Department of Planning & Infrastructure
GPO BOX 39
SYDNEY NSW 2001

MP-2006/209/D

5 June 2012

I refer to your letter dated 30 April 2012 seeking Council's comment in regard to the GPT Group's request to modify the above project pursuant to Section 75W of the Environmental Planning and Assessment Act 1979. Council has reviewed the modified proposal, and raises no objection to the proposed entrance modification in principle; however the following traffic comments should be taken into account in the Department's assessment of the modified proposal. For your information, comments are also provided in relation to S94A.

DRAWING TITLE:
WEST KEIRA
MARKET ST ELEVATION

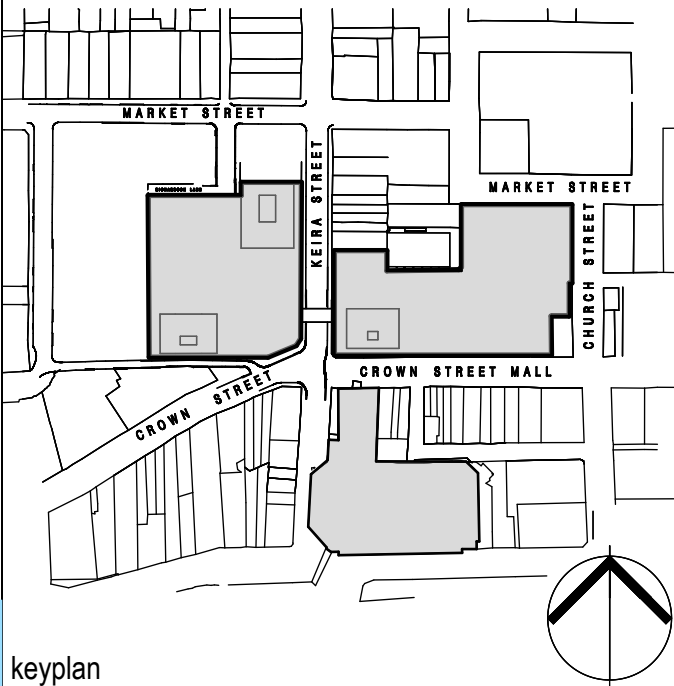
The proposed new access crosses the footpath in a busy pedestrian area. Pedestrians have the right of way under these arrangements so it is important that the development provides at least minimum pedestrian sightlines for pedestrian safety in accordance with AS2890.1 Figure 3.3. However the required sight triangles do not appear to have been provided on either side of the access, and a central column is shown within the access which would also obstruct a driver's view of pedestrians.

It is recommended that the Department undertake its own assessment of the proposed architectural feature at the driveway entrance.
